From: William Simcock
Sent: 11 January 2019 12:26
To: DCAdmin
Subject: FW: Updated consultation response 92 New North Rd 2018/92348 conservation response

From: Sue Oakley
Sent: 10 January 2019 16:32
To: William Simcock <William.Simcock@kirklees.gov.uk>
Subject: 92 New North Rd 2018/92348 conservation response

I have considered this revised proposal to convert vacant ground and lower ground floor apartments into offices along with a new rear access to the existing flats on the 1st and 2nd floors. This imposing ashlar stone building is a Grade II listed mid-C19 former villa which is located within the Greenhead Park / New North Road Conservation Area. The building has an ashlar stone façade with raised quoins and ranges of large sash windows carved stone detailing. The less prominent elevations are finished in fair faced stone walling, including the rear elevation which has a venetian window located centrally at first floor level. Below this is a projecting annexe on cast iron columns which dates back to the C19, and below this is a basement entrance doorway. To each side of the annexe is an ornate cast iron balcony, one of which has been converted into an escape route with an adde

PROPOSED ALTERATIONS TO REAR ELEVATION
SCALE 1:100

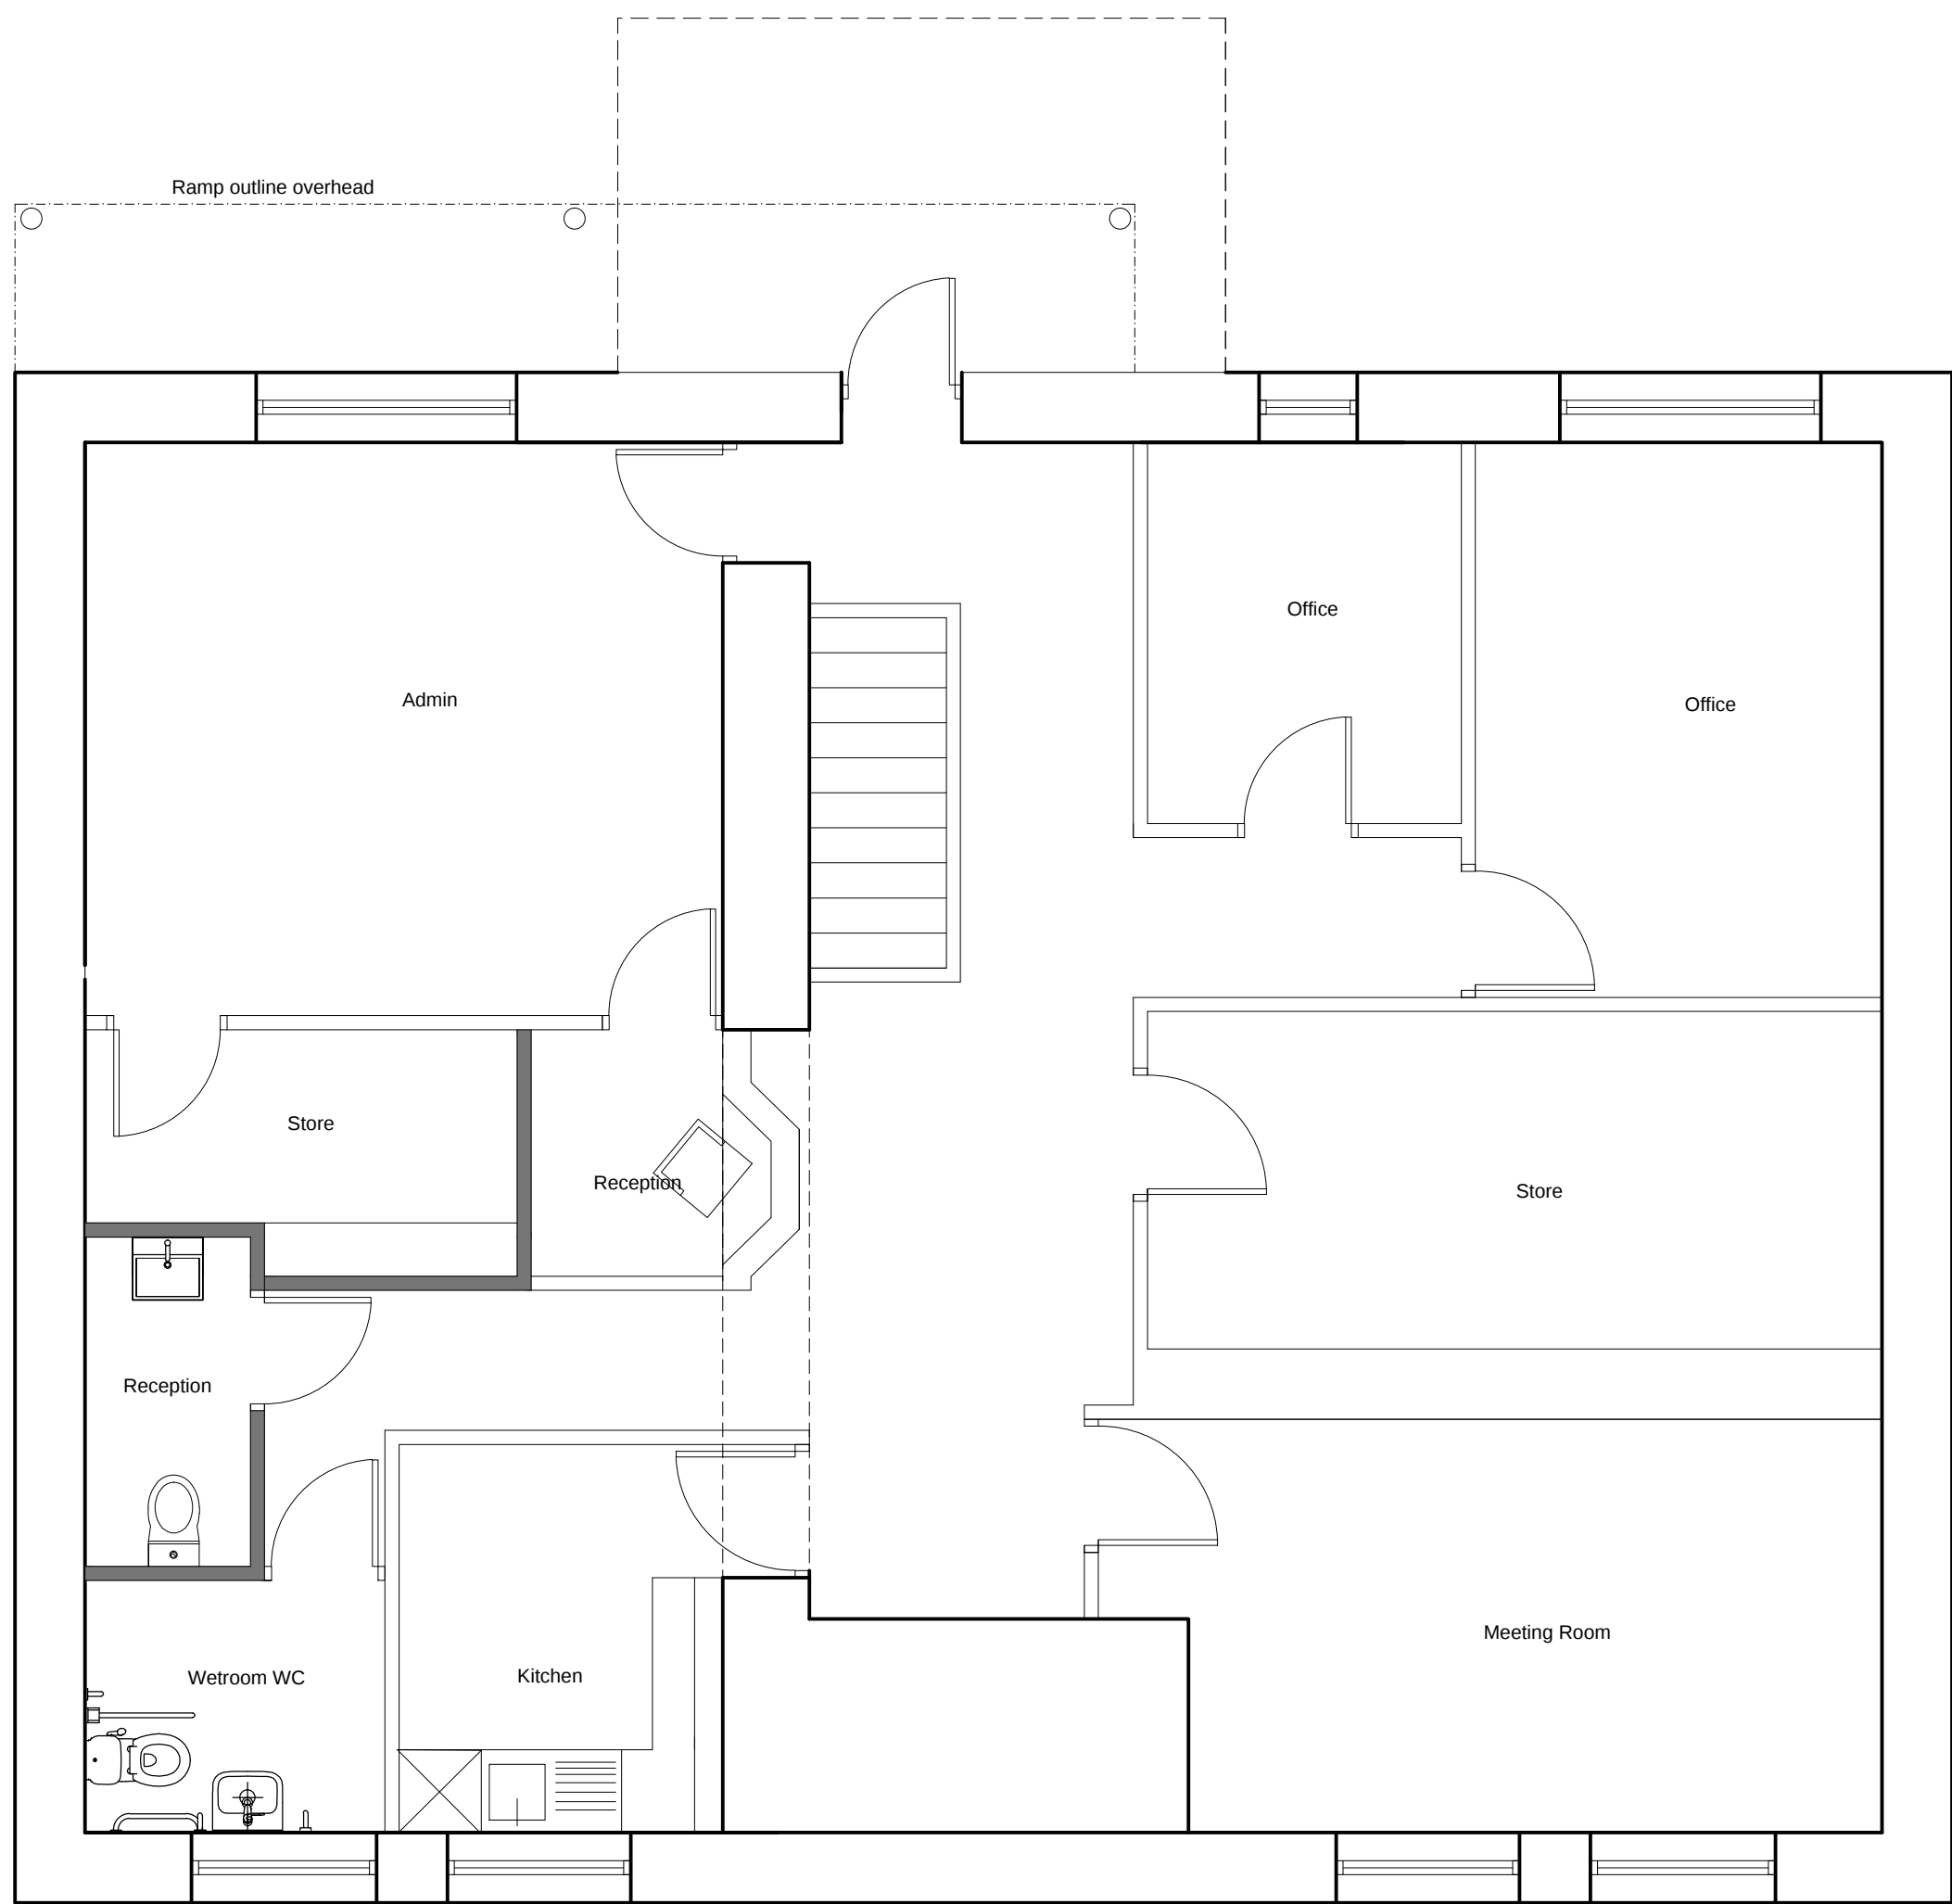
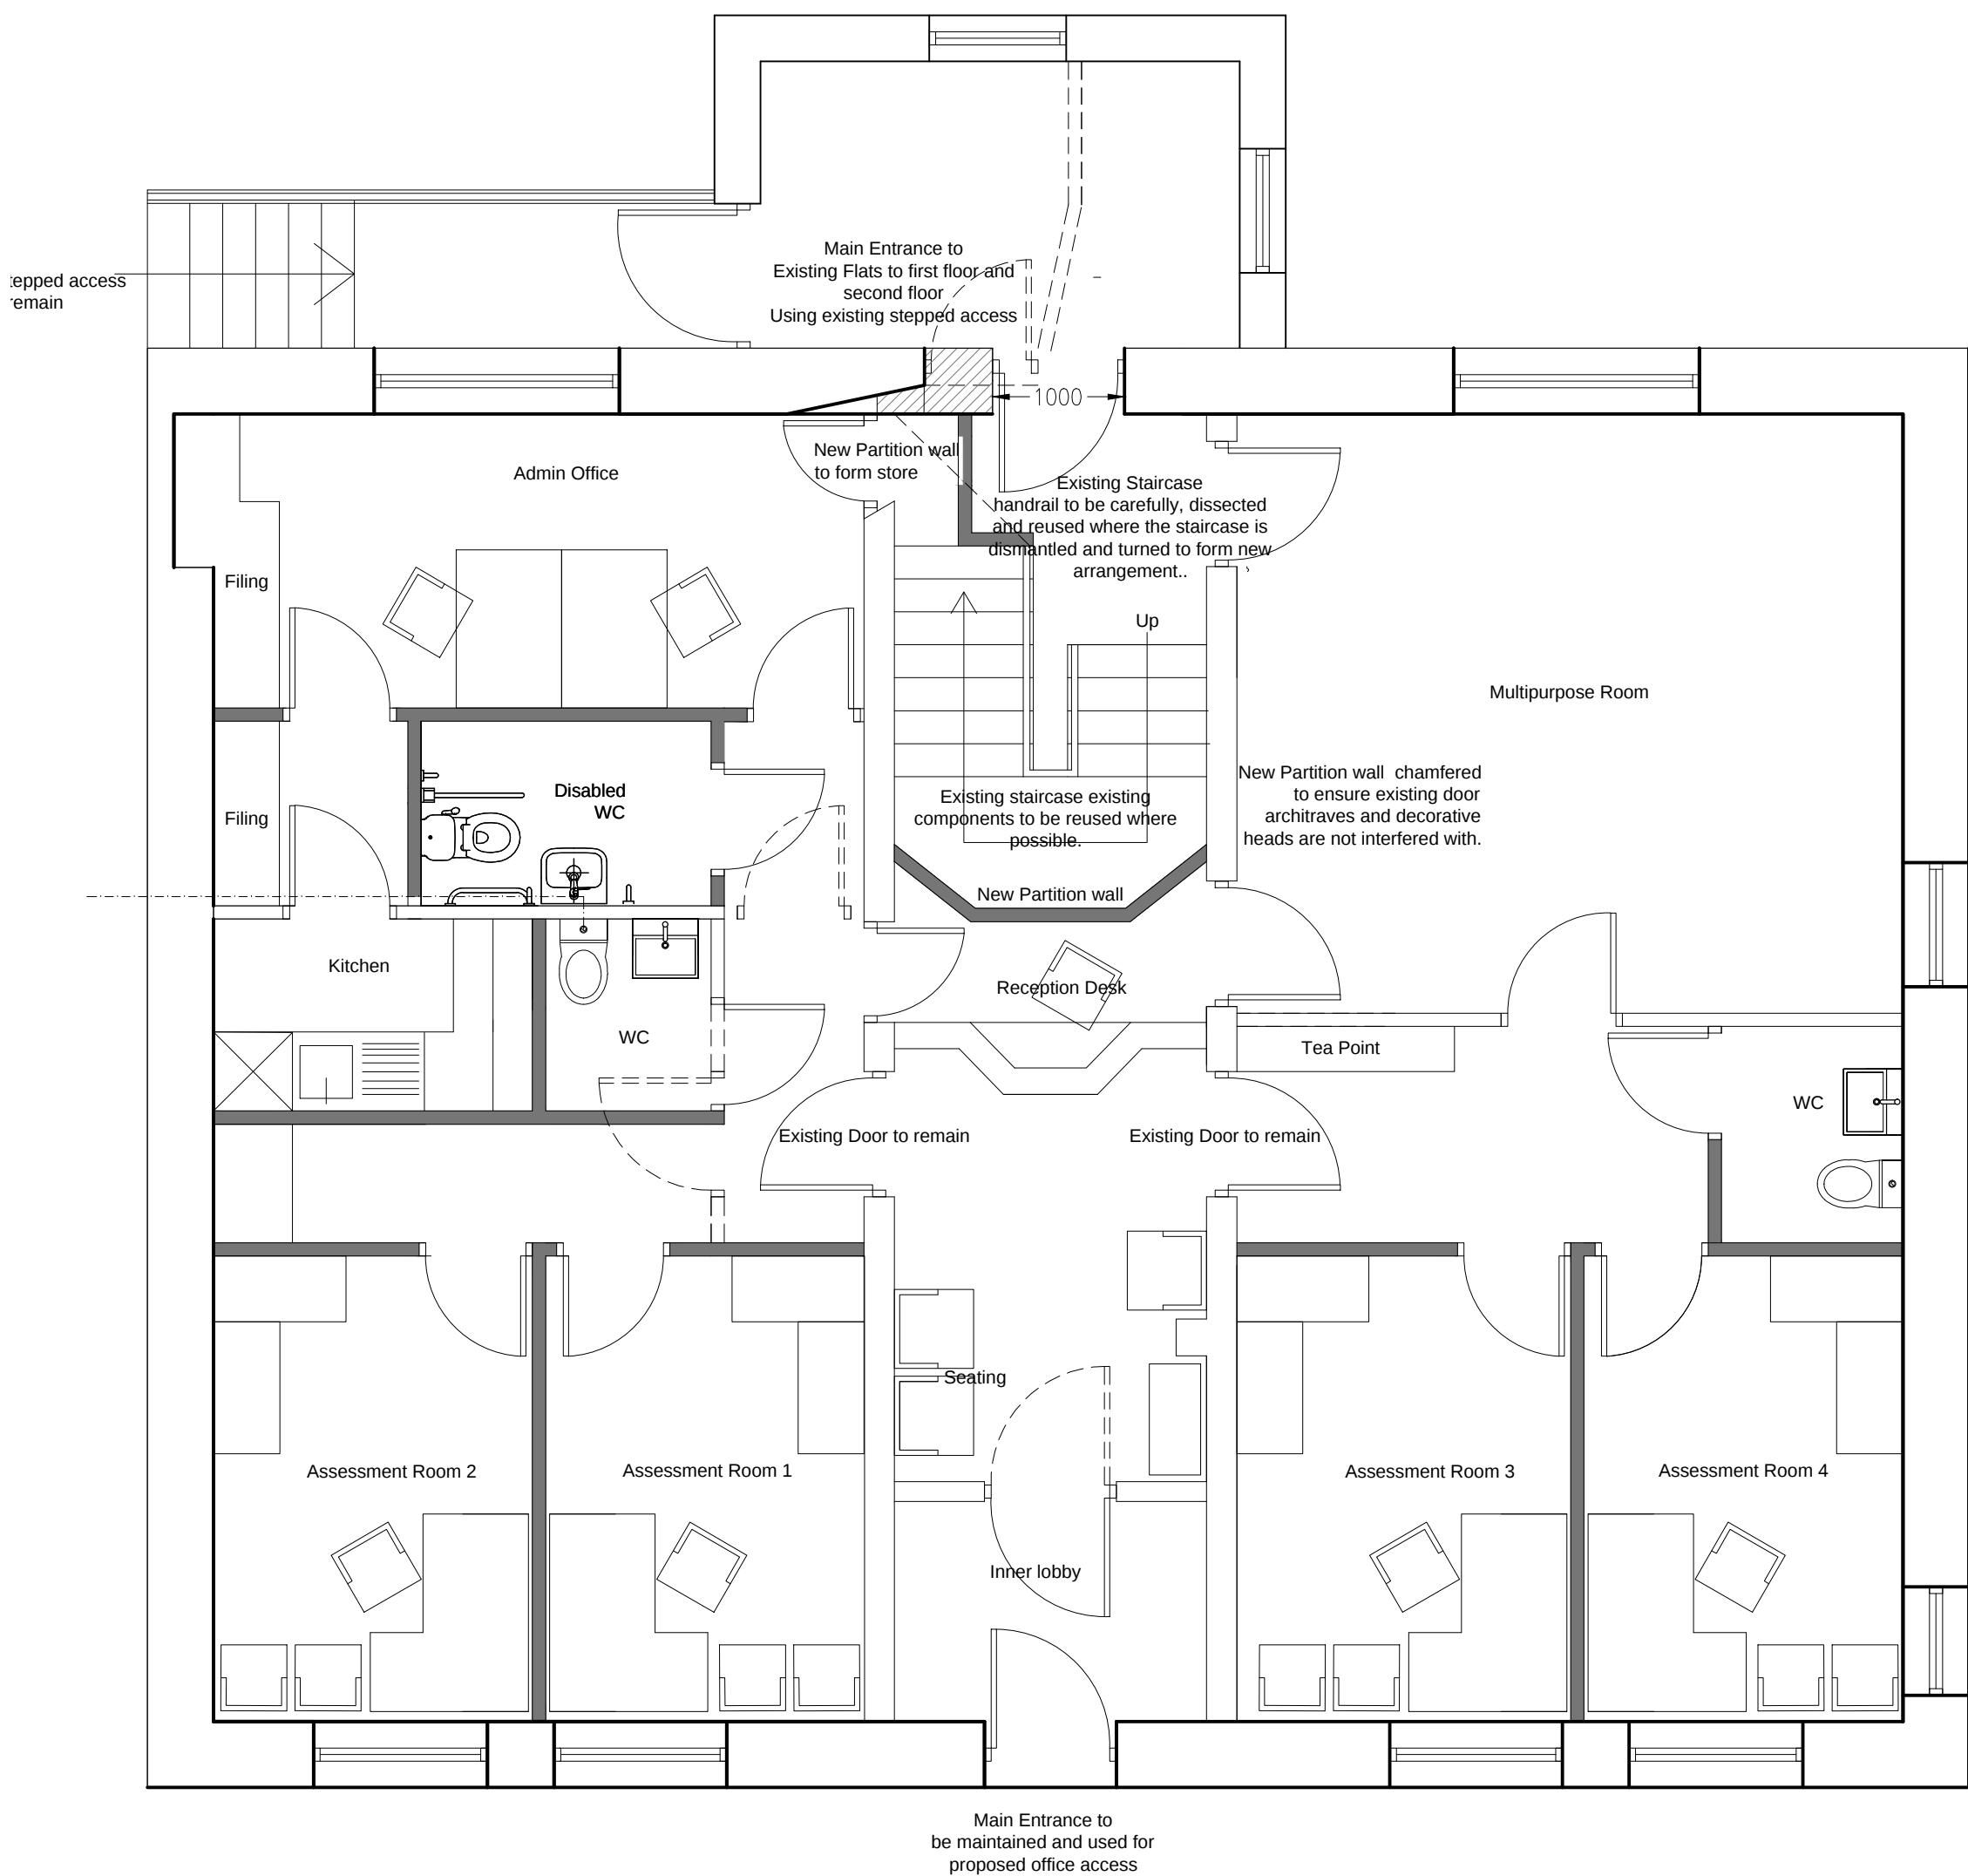
The applicant proposes alterations to the rear of the property to provide a separate rear access to the apartments on the upper floors. The heritage statement states that the existing wrought iron balconies at the rear of the

building will be repaired and restored, with a short addition to extend the right hand balcony to a new entrance door inserted into the side of the rear annexe. The drawing shows a replacement balcony, wider than the existing, with the existing decorative infills incorporated into the handrail design. As the existing balcony is relatively low, a new handrail will be installed above the existing to ensure compliance with building regulations. This rail should be painted black to match the existing. The proposed door is acceptable and should be painted black to match the existing. I consider these interventions to be acceptable as historic fabric will be restored and retained with minimal intervention, while providing a reasonable width access to the apartments.

The heritage statement should be amended to omit the demolition of the rear annexe and the provision of a rear ramped access which is shown on the proposed drawing as an external staircase.
